# Rezoning Transportation Analysis

Petition Number: #2022-066

**From:** Jake Carpenter, PE

Date	Description
09-28-2022	First Review (AO)
10-26-2022	Second Review (IW)
09-25-2023	Third Review (IW)

ILLUSTRATIVE SITE PLAN
FOR
PETITION # 2022-066
ALBEMARLE ROAD APARTMENTS
CHARLOTTE, NORTH CAROLINA

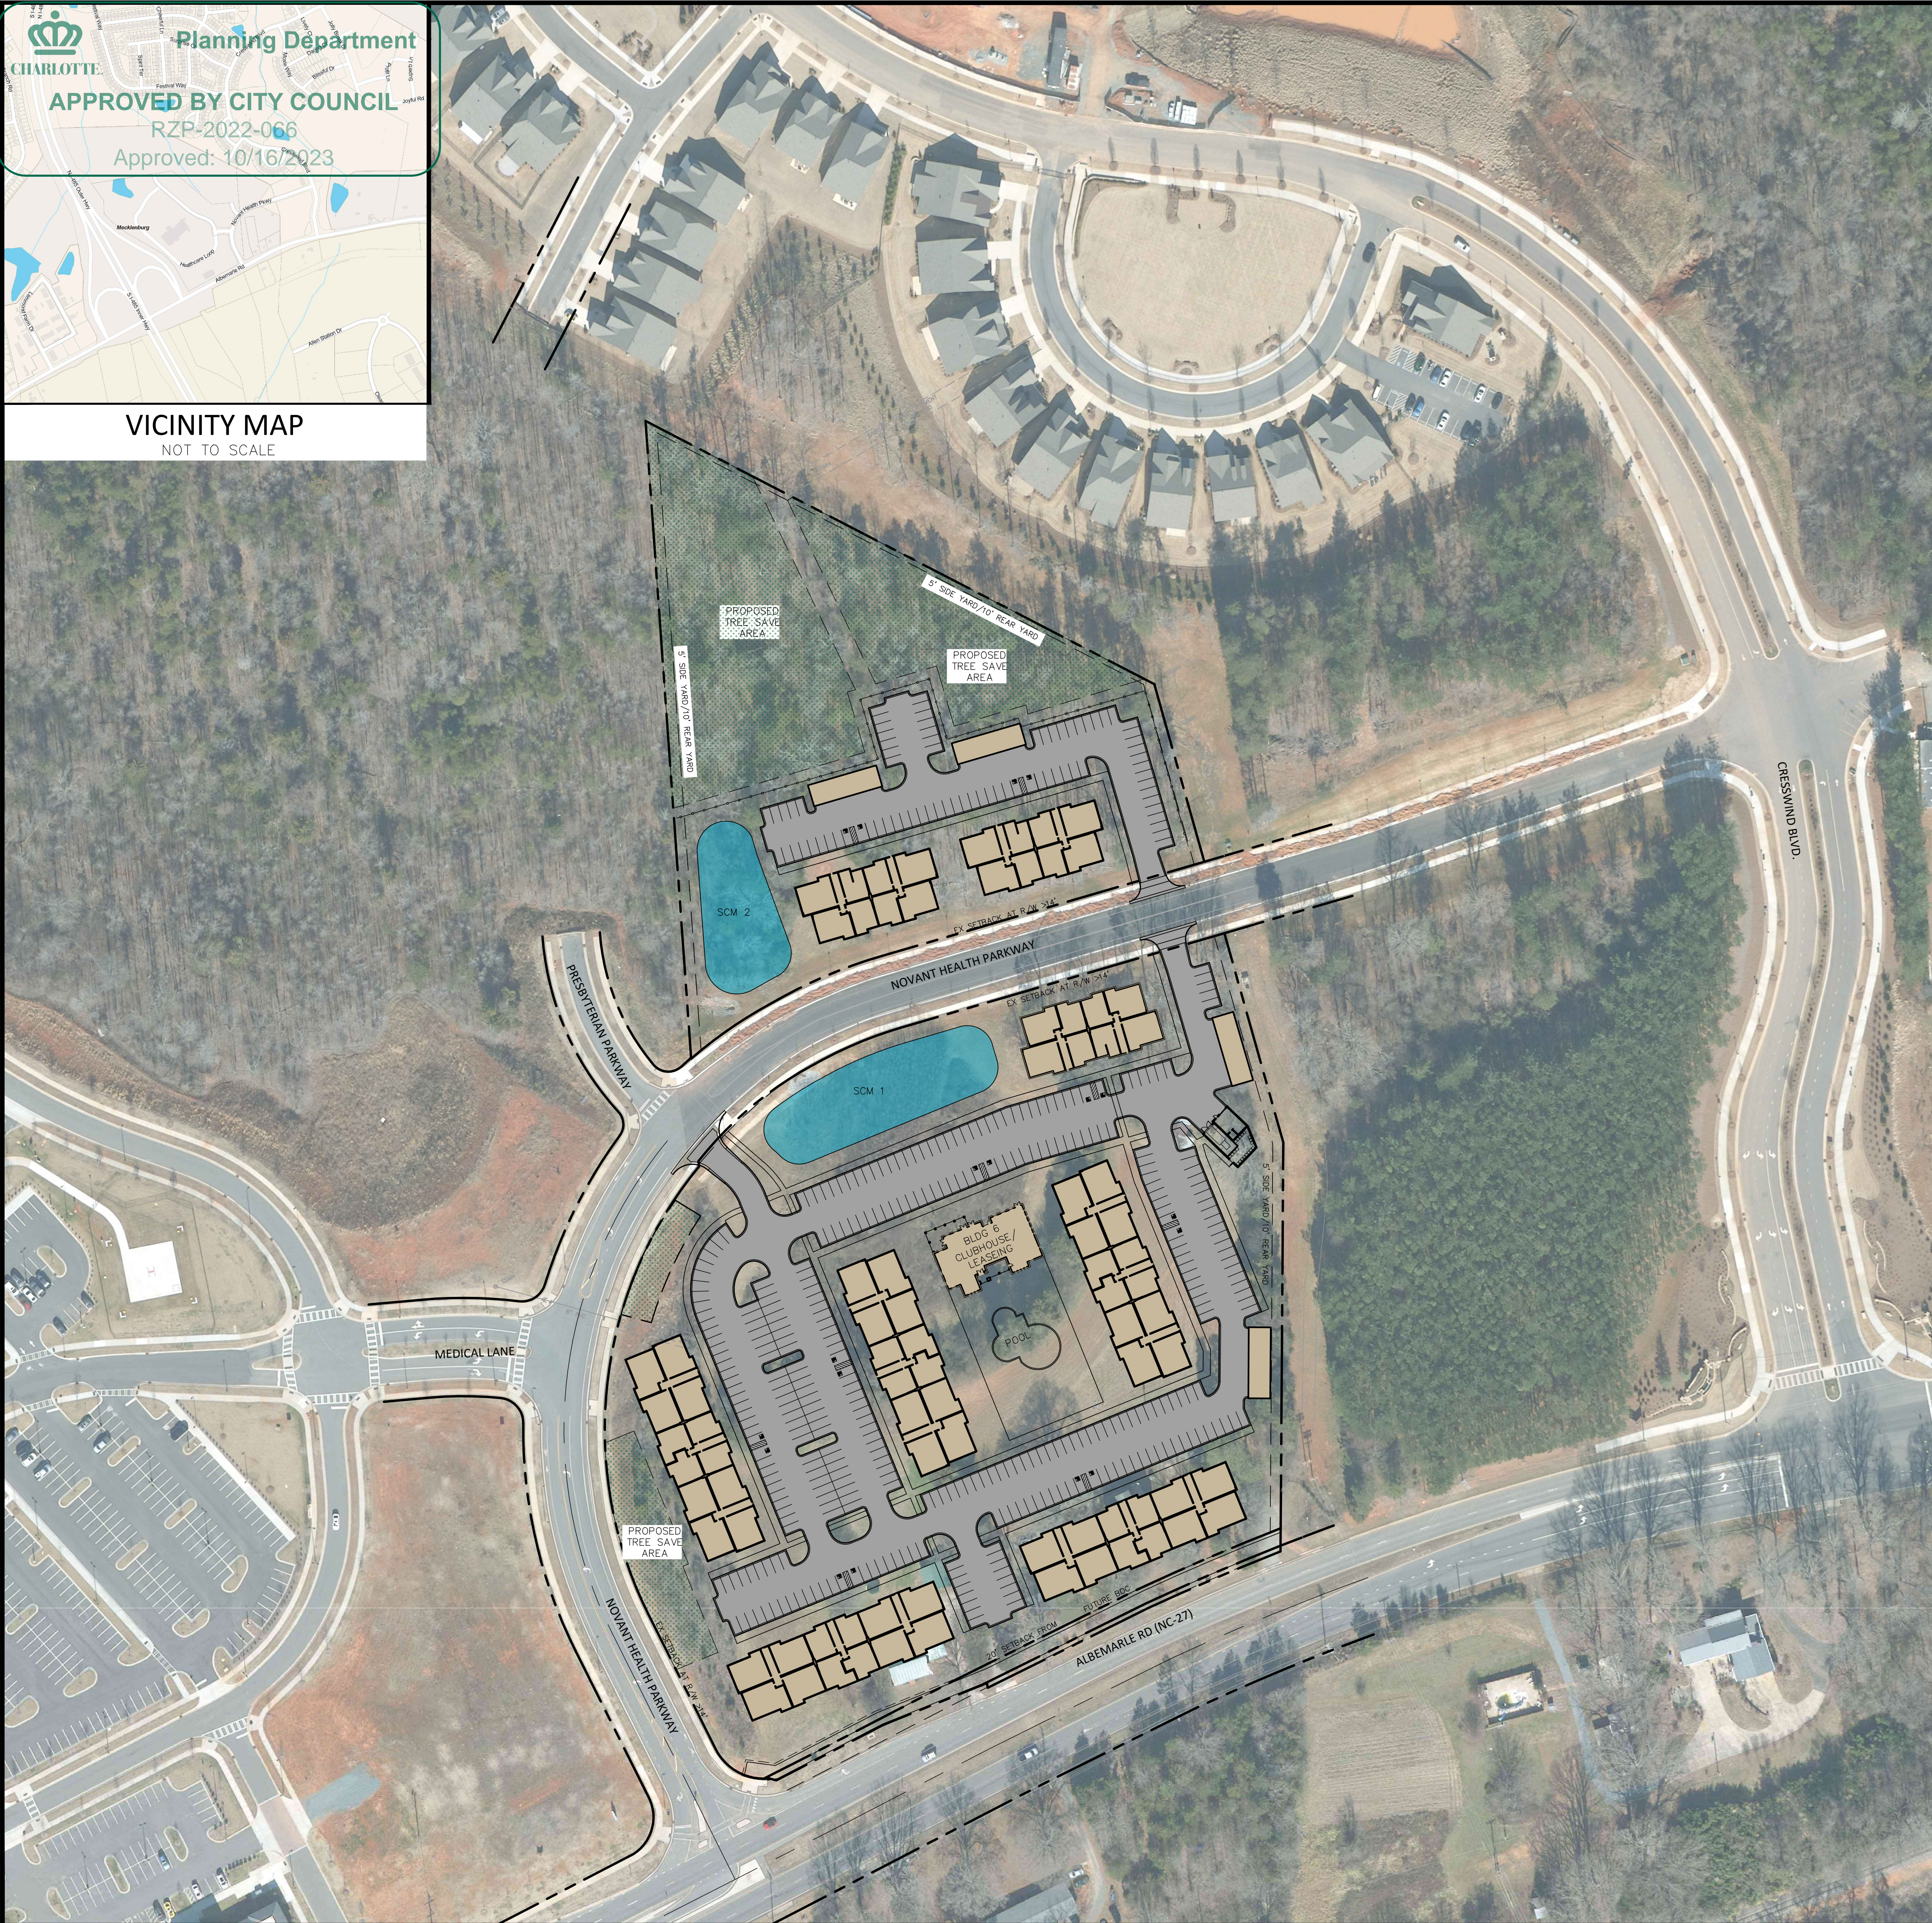
1. ~~**Curbline:** The proposed zoning district has a setback measured from back of the existing or proposed future curbline.~~

~~**Albemarle Road:** Future curbline location: 44 feet from centerline of Albemarle Road.~~

~~Label and dimension the curb and gutter from the centerline for each road on the site plan.~~

3. ~~**Outstanding Comment from 09-28-2022** Revise site plan and conditional note(s) to commit to dedicate 100 feet of right-of-way or existing right-of-way, whichever is greater from the road centerline of Albemarle Road. The site plan shall label and dimension the right-of-way from the road centerline of Albemarle Road and Novant Health Parkway.~~

4. ~~Revise site plan to remove 35x35 sight triangle from the intersection of Albemarle Road at Novant Health Parkway. See advisory information regarding sight triangles.~~

5. ~~Revise site plan and conditional note(s) to commit to maintaining existing bike lane along Novant Health Parkway.~~
6. ~~A site plan note(s) specifying dedication and fee simple conveyance of all rights of way to the City before the site's first building certificate of occupancy is issued as needed. CDOT requests rights-of-way set at 2' behind back of sidewalk where feasible.~~

9. ~~Revise site plan to construct a 12-foot /multi-use path on Albemarle Road. The site plan shall label and dimension both items from the back of curb and gutter. The entire facility must be outside of the right of way and within a public access easement. Add conditional note committing to construction and maintenance of the 12-foot multi-use path on Albemarle Road.~~

~~CDOT worked with petitioner to only request 73.5' of right of way to account for the current future cross section.~~
